Client Store Property Investments Ltd
Project Brook Lane, Rustington
Element Ref Site Access Roundabout
Drawing ref 10D
Design Speed 30mph (60kph)

Mini-Roundabout Junction Design Check
TD 54/07

drawing number SPRUST(BROOK LANE).1/10 rev. D

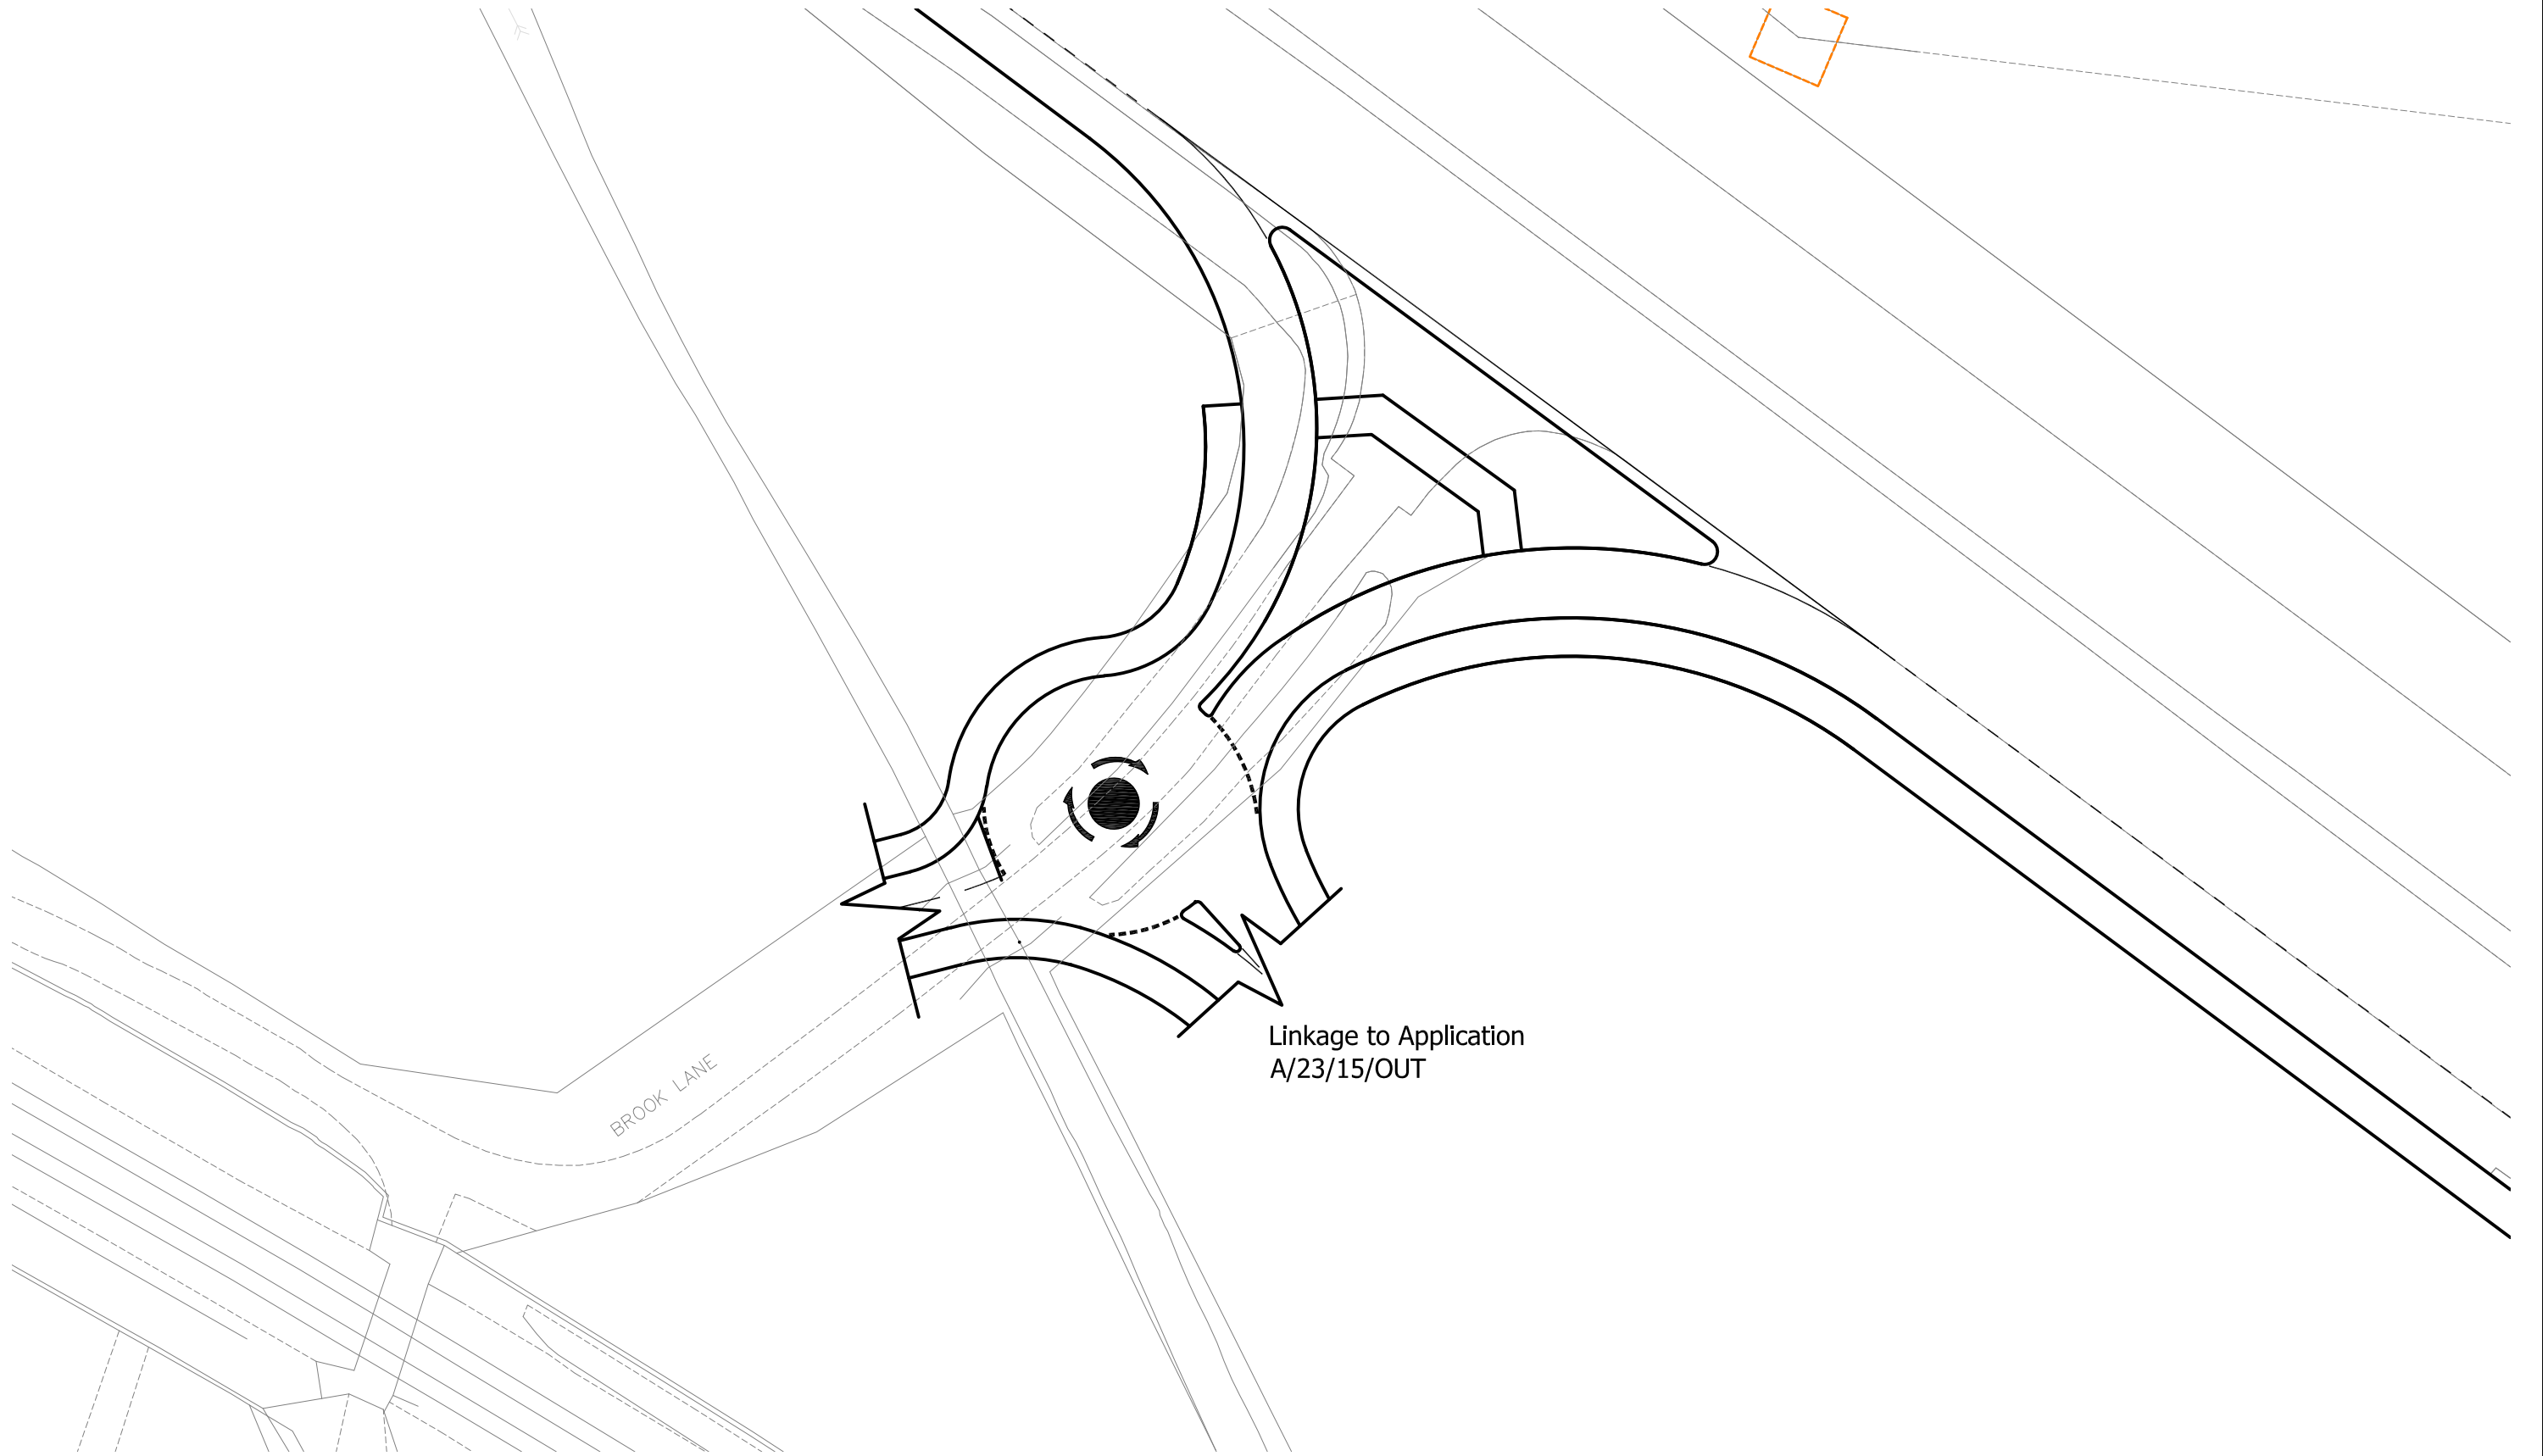
6.1	The inscribed circle diameter (ICD) of a mini-roundabout is the diameter of the largest circle that can be inscribed within the junction kerbs. The maximum ICD of a mini-roundabout is 28m. Above this dimension, a normal roundabout can accommodate the largest design vehicle and must be used. For further guidance see TD 16 (DMRB 6.2.3).	Y	20m ICD provided		20m ICD provided		20m ICD provided

6.8	The following requirements together determine the location of the white circle as illustrated in Figures 6/2 and 6/3: (i) It must be as large as practicable up to a maximum of four metres diameter and positioned using the inside of the swept path of cars. (ii) The centre of the design vehicle path must be at least 1 metre from kerbs, the perimeter of the white circle, and from any road marking separating opposing traffic.(iii) A minimum design vehicle path radius of 6 metres, at the centre of the path, must be allowed for right turns. For this radius the vehicle path should be widened to 3m at the apex of the turn. (iv) For mini-roundabouts with two or three entry lanes (although three lane entries are not recommended, see paragraph 2.12), the width of the circulatory carriageway must be sufficient to enable cars to travel two abreast around the white circle.	Y	The white circle is provided at 4m diameter		The white circle is provided at 4m diameter		The white circle is provided at 4m diameter

6.29	The minimum requirement for road markings on the approaches to kerbed physical islands is to provide warning lines to diagram 1004 (see Chapter 5, paragraph 4.23 of the Traffic Signs Manual). However, if a kerbed island is at risk of being overrun by approaching, circulating or exiting vehicles, it must be positioned at least 0.5m clear of any vehicle swept path.	N	Swept path plots provide less than 0.5m clearance to islands	Islands could be changed to thermoplastic if required	Swept path plots provide less than 0.5m clearance to islands	Islands could be changed to thermoplastic if required	No comments required	No comments required

6.32	The minimum lane width permitted at the give way line is 3.0m, except at a two lane approach where the minimum lane widths can be reduced to 2.5m, provided heavy goods vehicles and buses do not frequently use the entry. The maximum lane width at the give way line for a single lane entry is 4.0m	N	5.3m lane entry width exceeds the 4m maximum width at the give way line	The width at the give way line, as a result of the flare, is required to accommodate swept path plots	3.7m lane entry width	No comments required	4.3m lane entry width exceeds the 4m maximum width at the give way line	The width at the give way line, as a result of the flare, is required to accommodate swept path plots
